Please use latest GEC Checklist. Checklist can be found at:
<https://publicworks.elpasoco.com/stormwater/>

**EL PASO COUNTY PLANNING AND
 COMMUNITY DEVELOPMENT
 DEPARTMENT**

GRADING AND EROSION CONTROL PLAN CHECKLIST

HORIZ. SCALE: 1"=40'
 VERT. SCALE: N/A
 SURVEYED: RIDGELINE
 CREATED: 10/11/19
 PROJECT NO: 031901
 SHEET: C1.1

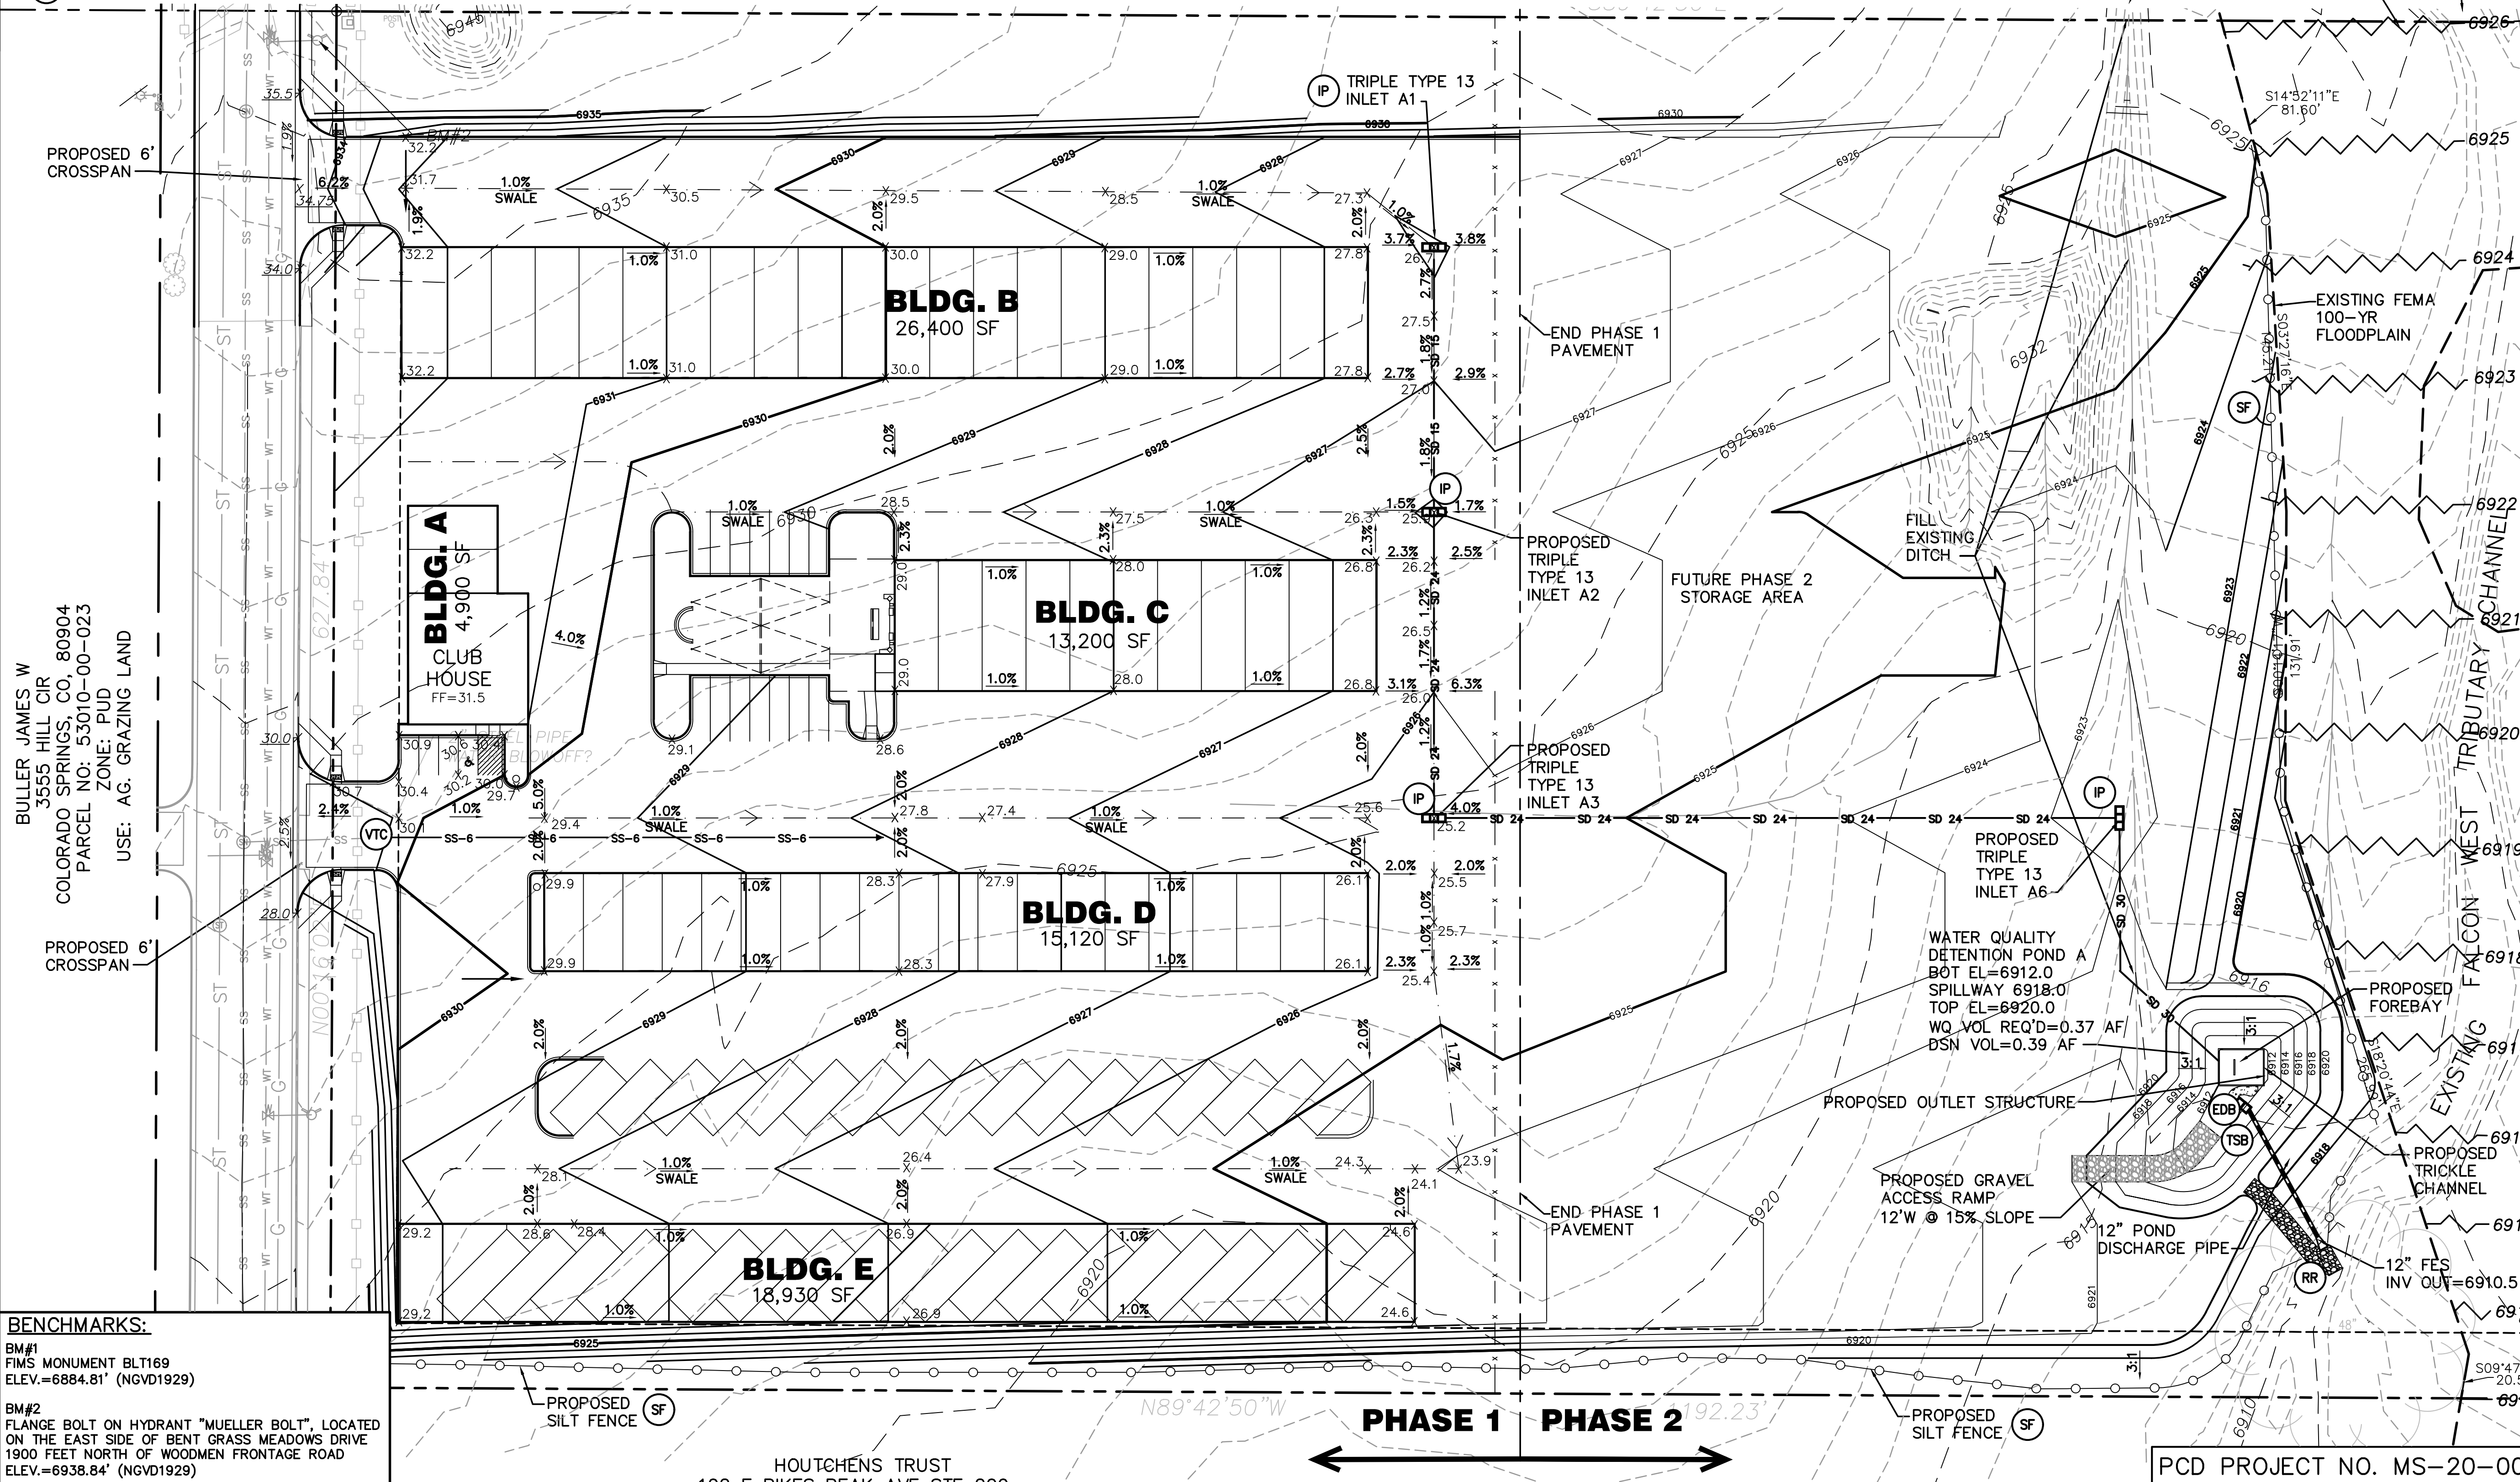
Applicant	PCD
1. GRADING AND EROSION CONTROL PLAN			
a	Vicinity map.	Y	✓
b	Adjacent city/town/jurisdictional boundaries, subdivision names, and property parcel numbers labeled.	Y	✗
c	North arrow and acceptable scale (1"=20' to 1"=100').	Y	✓
d	Legend for all symbols used in the plan.	Y	✓
e	Existing and proposed property lines. Proposed subdivision boundary for subdivision projects.	Y	✓
f	All existing structures.	Y	✓
g	All existing utilities.	Y	✓
h	Construction site boundaries.	Y	✓
i	Existing vegetation (notes are acceptable in cases where there is no notable vegetation, only grasses/weeds, or site has already been stripped).	Y	✓
j	FEMA 100-yr floodplain.	Y	✓
k	Existing and proposed water courses including springs, streams, wetlands, detention ponds, stormwater quality structures, roadside ditches, irrigation ditches and other water surfaces. Show maintenance of pre-existing vegetation within 50 feet of a receiving water.	Y	✓

v	All proposed temporary construction control measures, structural and non-structural. Temporary construction control measures shall be identified by phase of implementation to include "initial," "interim," and "final" or shown on separate phased maps identifying each phase.	Y	✗
w	Vehicle tracking provided at all construction entrances/exits. Construction fencing, barricades, and/or signage provided at access points not to be used for construction.	Y	✓
x	Temporary sediment ponds provided for disturbed drainage areas greater than 1 acre.	Y	✓
y	Dewatering operations to include locations of diversion, pump and discharge(s) as anticipated at time of design.	Y	N/A
z	All proposed temporary construction control measure details. Custom or other jurisdiction's details used must meet or exceed EPC standards.	Y	✗
